Town & Country Planning Act 1990 (as amended)
Town and Country Planning (Development Management Procedure) (England) Order 2015

Application No: FG/37/22/PL
Site Address: 61 Sea Lane Gardens Ferring BN12 5EG
Description of works: 1 No dwelling. This site is in CIL Zone 4 and is CIL Liable as new dwelling.

Thank you for your internet representation made on 28th March 2022 which has been recorded as an objection with the comments as follows:

Client:		
Address of Works: 61 Sea Lane Gardens Ferring West Sussex BN12 4TB		
Drawing Title: Proposed Dwelling Planning		
Paper Size: A3	Date: Dec. 2021	
Job Number: AR-165B	Drawing Number: 01	Revision: Revision

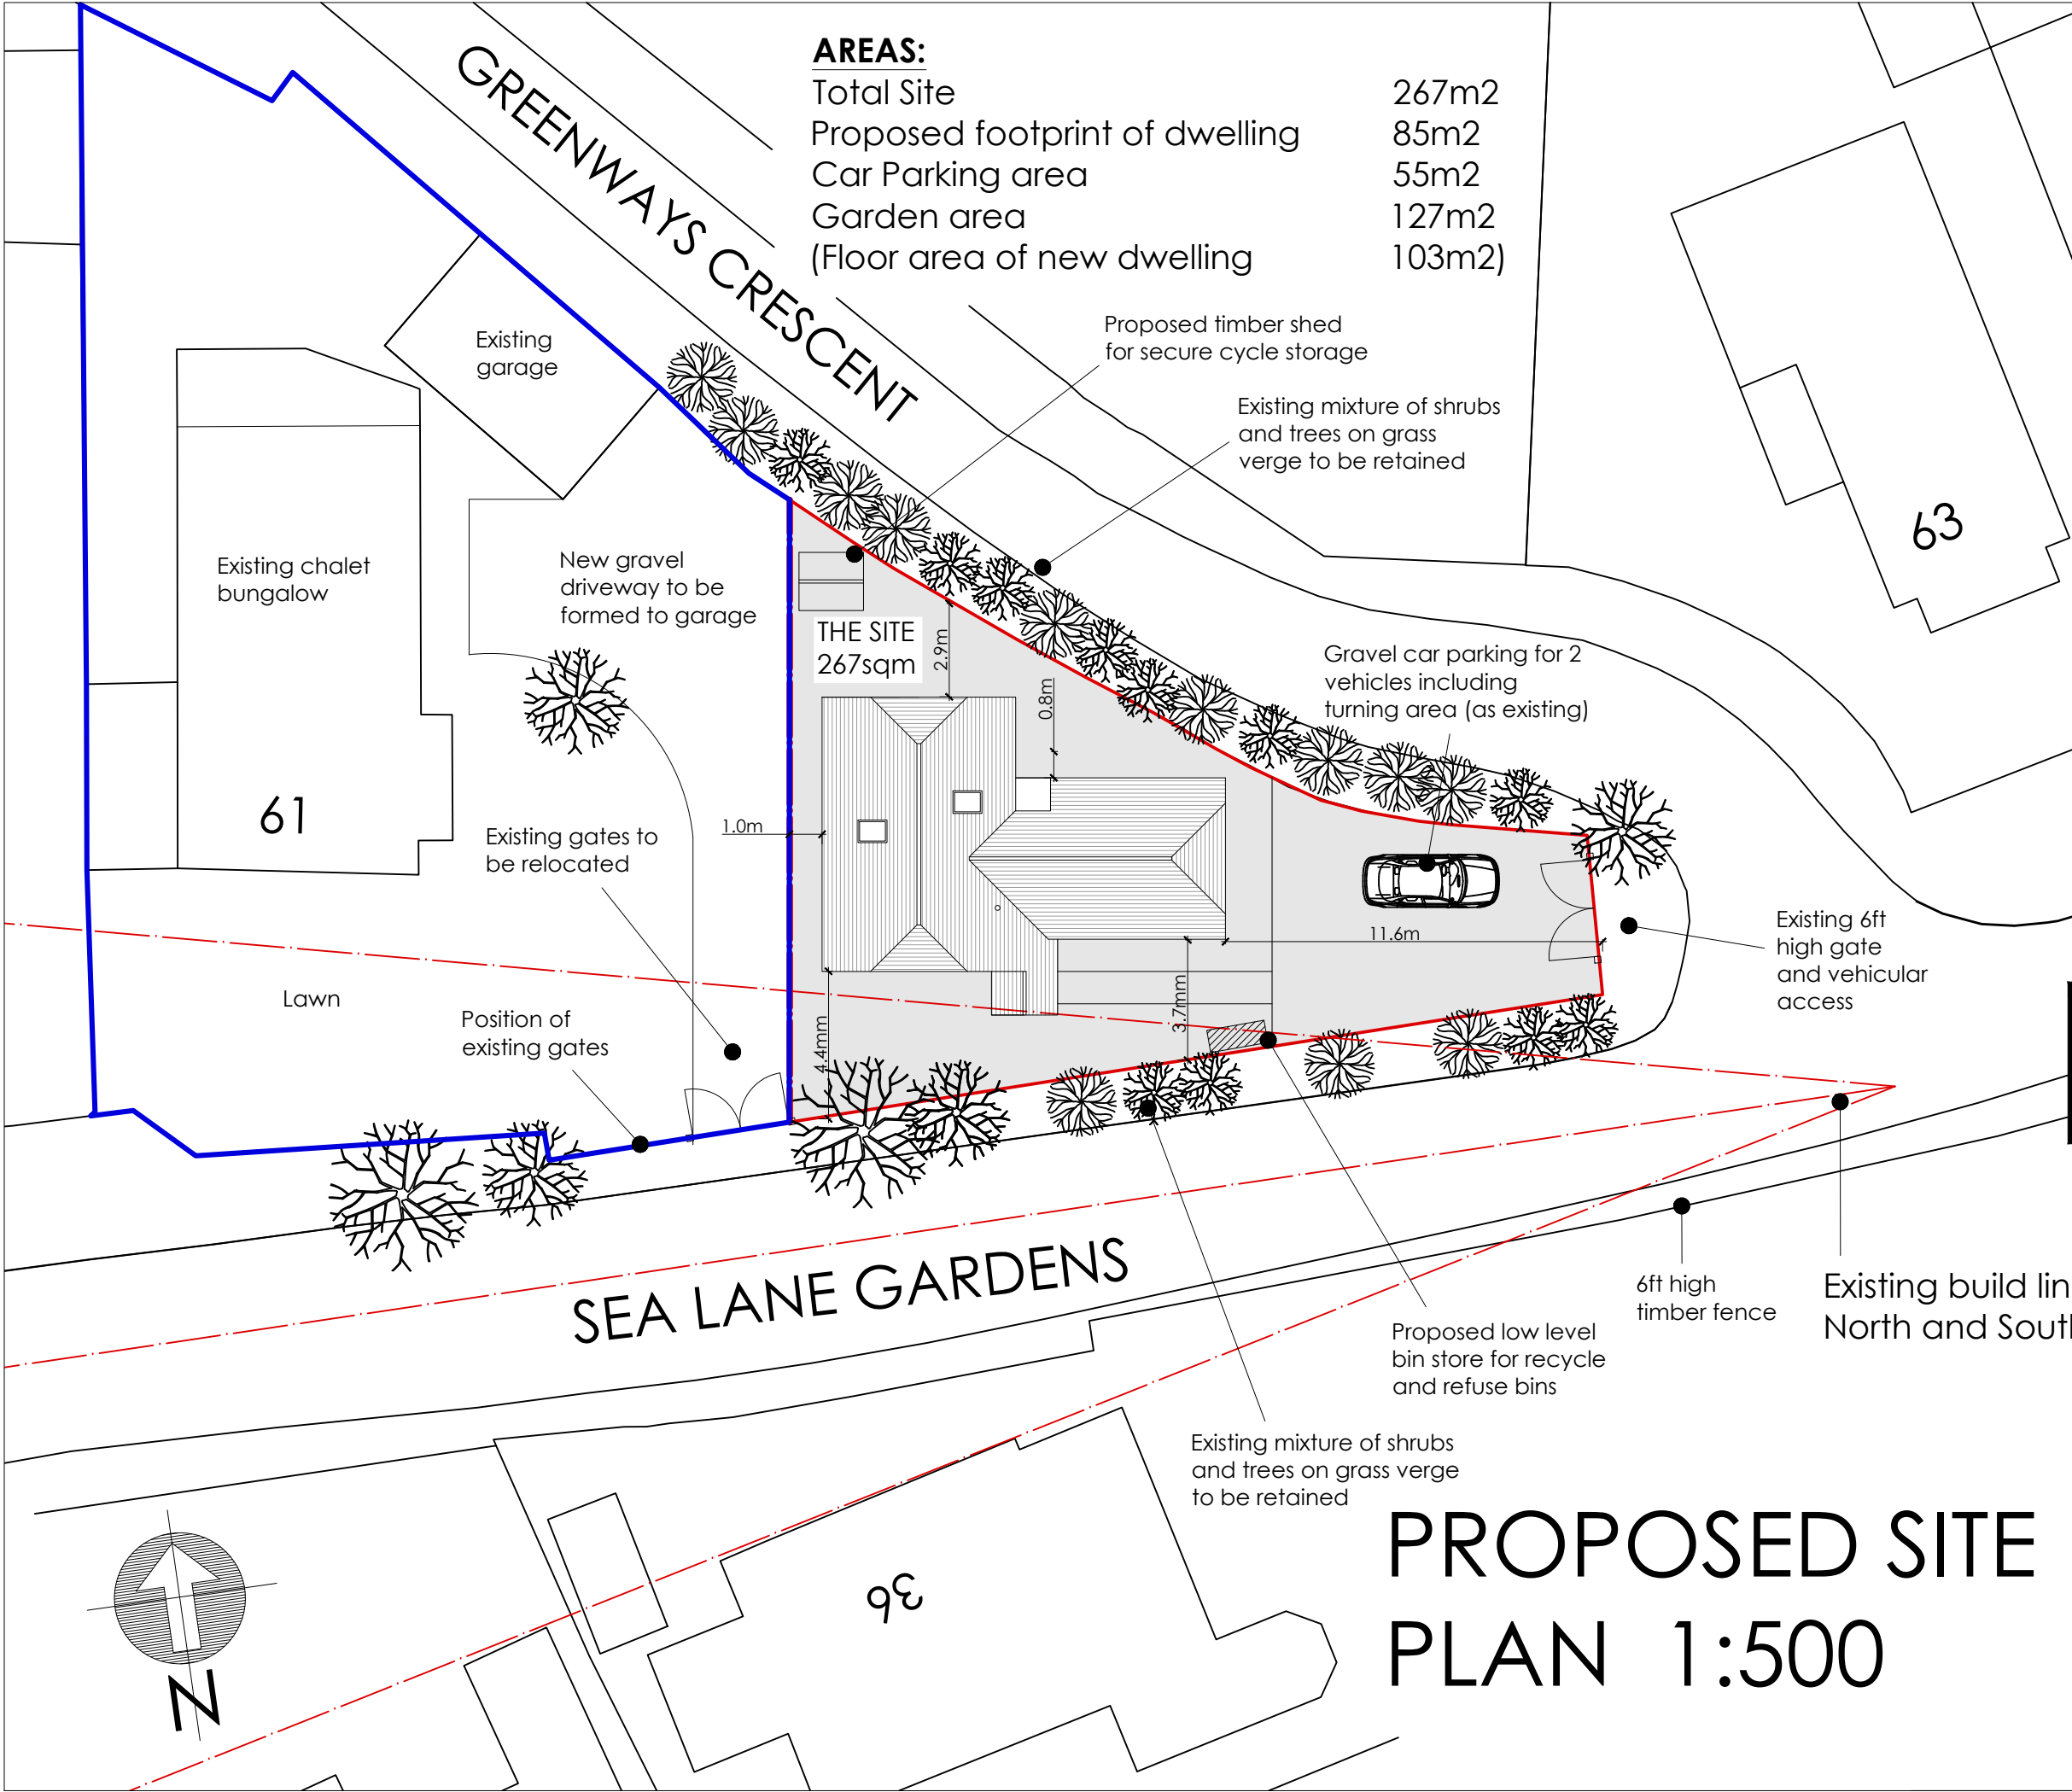
1. This small site allows only a 1 metre gap from the proposed new building to the western boundary fence and other parts of the new building would be very close to the site boundary both north and south showing that the house is too big for the site.

5. Windows at first floor level in the new property to the North and South overlook the houses at 10 Greenways Crescent and 36 Sea Lane Gardens.
6. The Design Access and Planning Statement indicates that existing planting externally to the boundary of this site will obscure views of the new house. This planting is not in the control of the owners of 61 Sea Lane Gardens although already removal has occurred of a substantial tree at the right-hand side of the proposed vehicle entrance point that is shown on page 2 of the design access and planning statement.

7. There is very little garden area provided and this is not in keeping with the majority of other local properties

# PROPOSED CAR PARKING PLAN 1:50

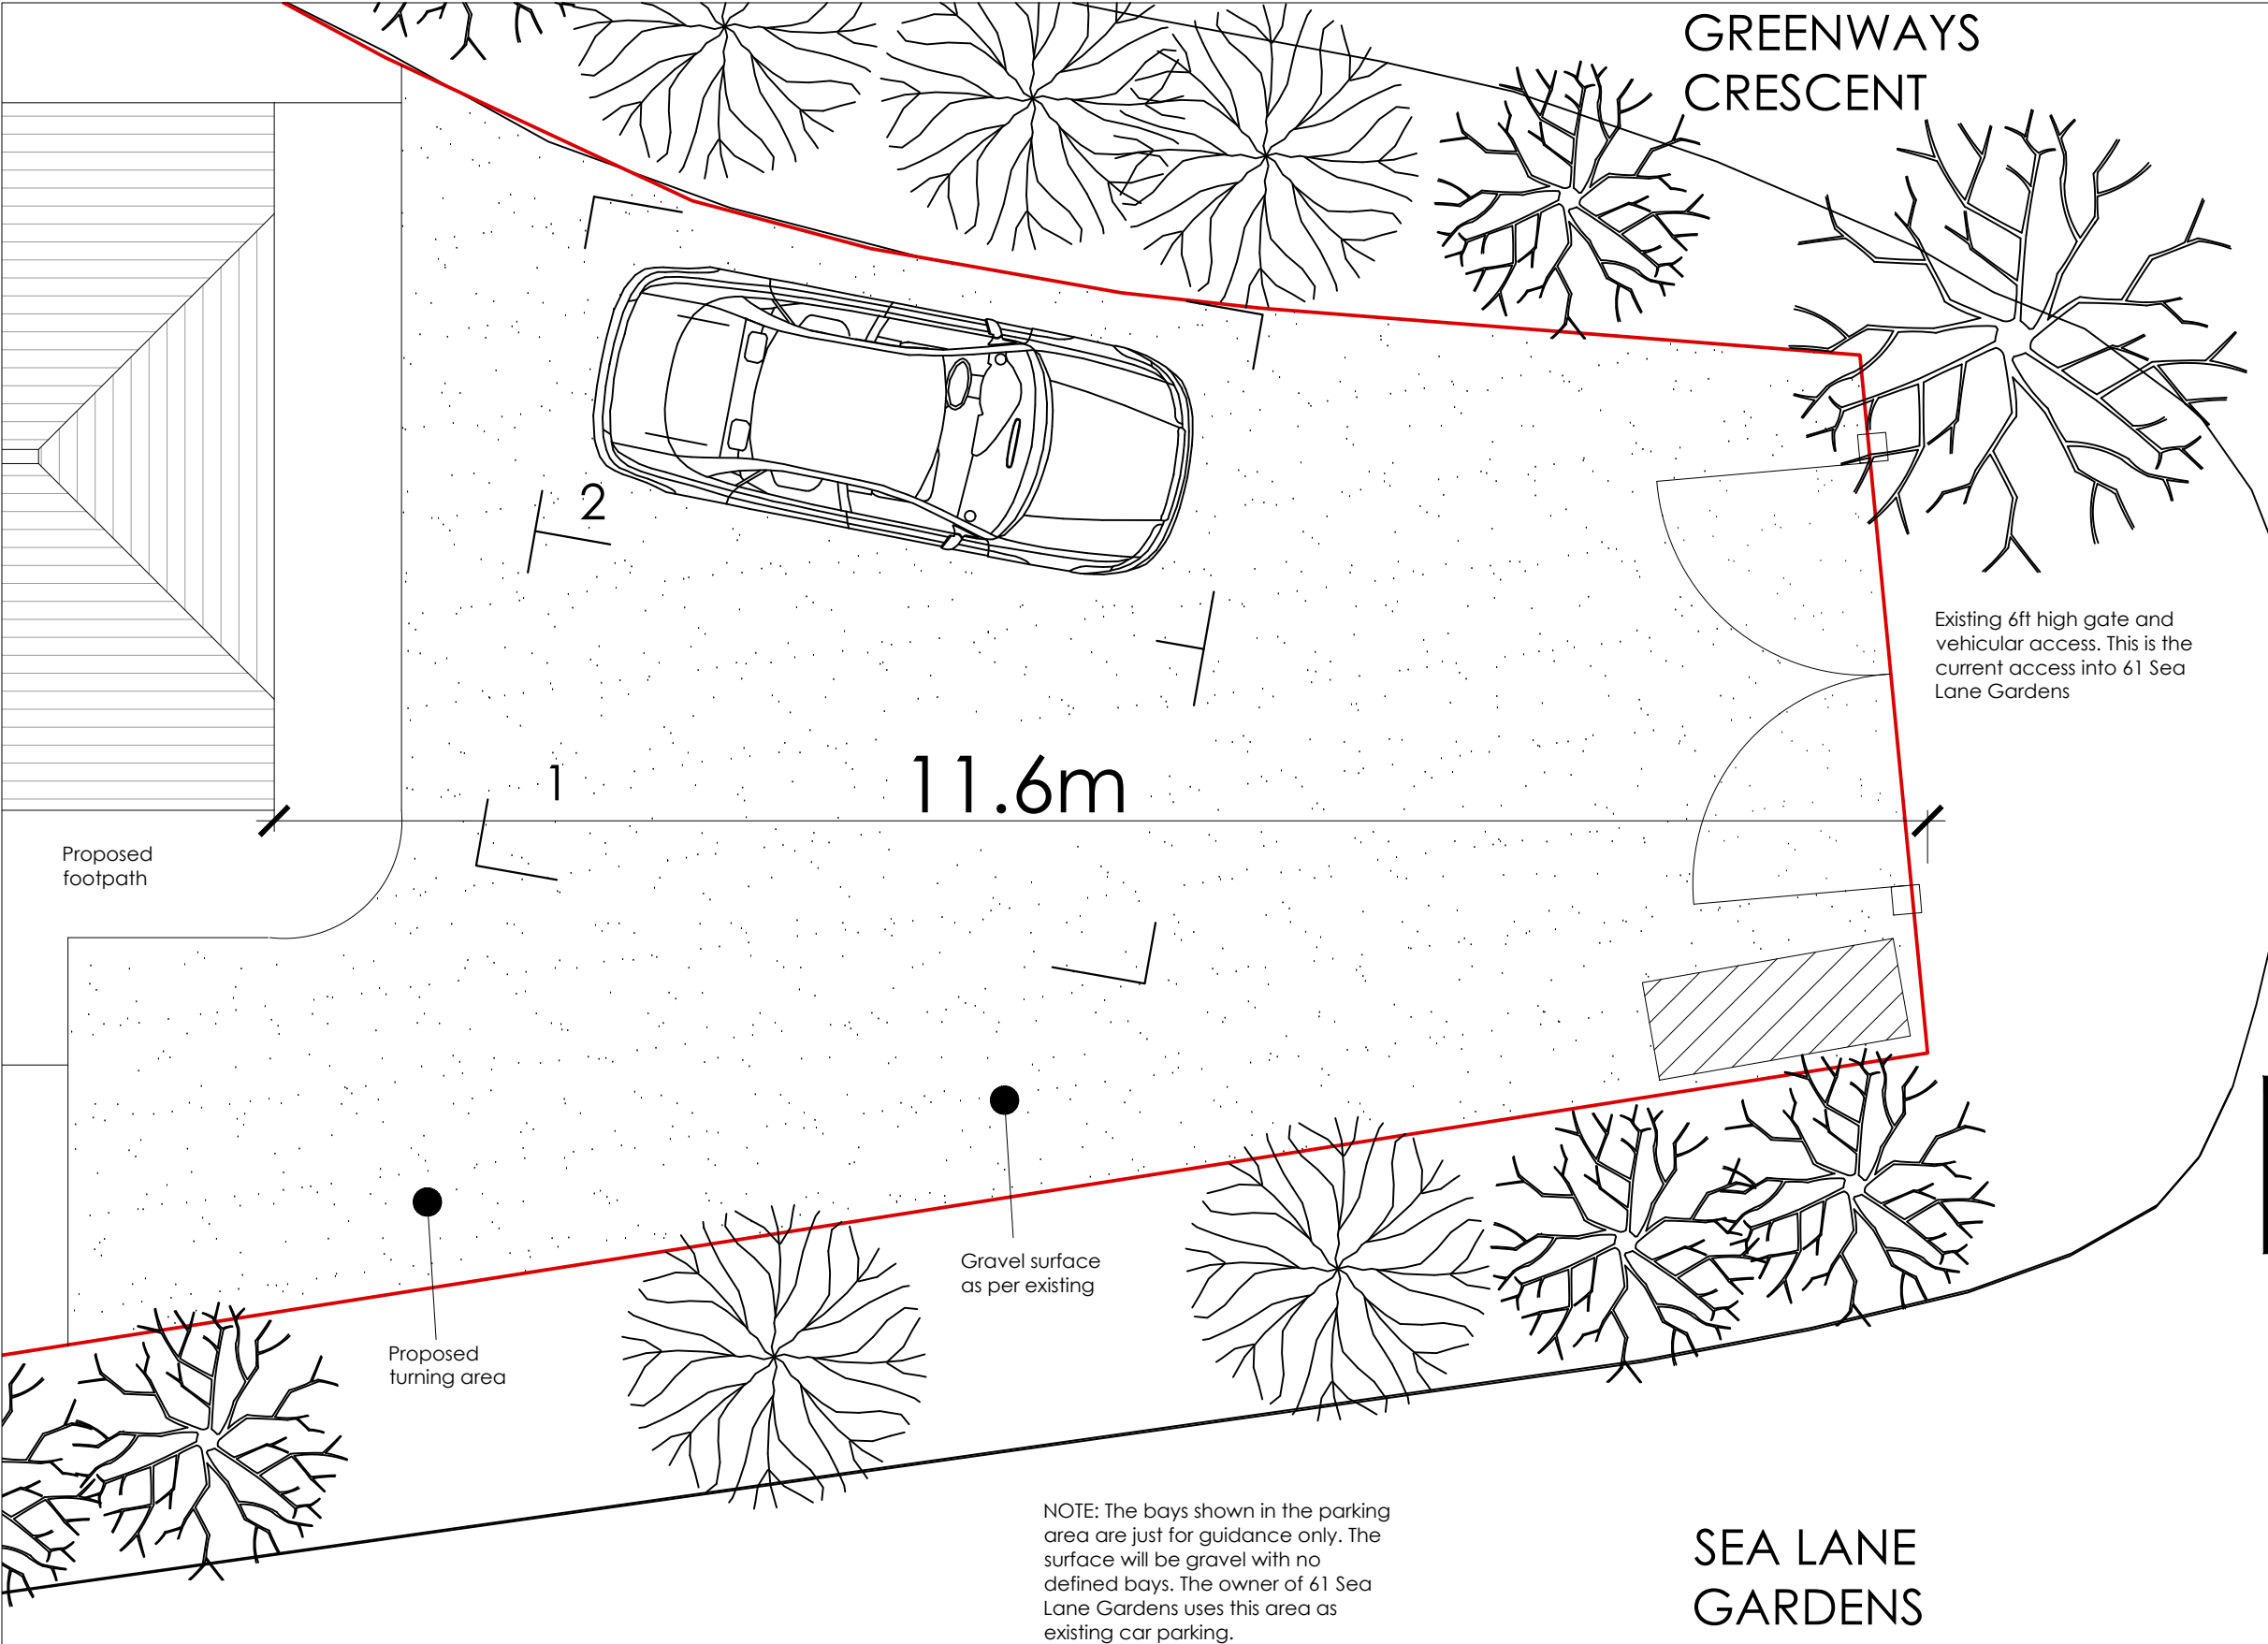
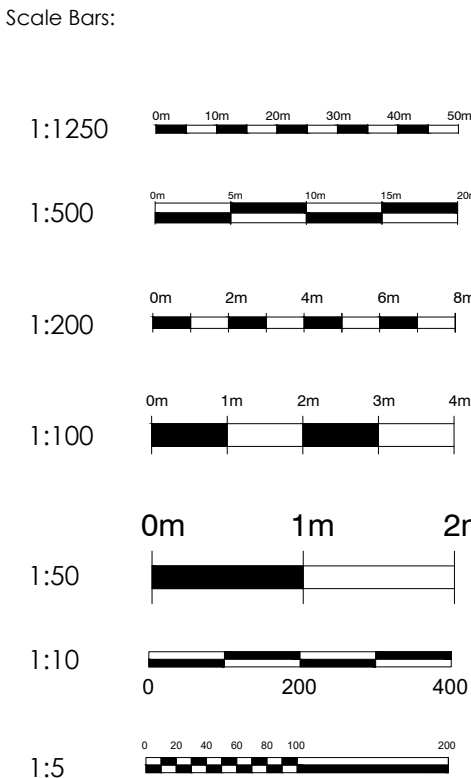
2. The parking area is small with the result that vehicles choosing to reverse out at the junction of Greenways Crescent and Sea Lane Gardens.
3. There is insufficient space for delivery vehicles in the parking area and this will result in parked vehicles obstructing the junction.
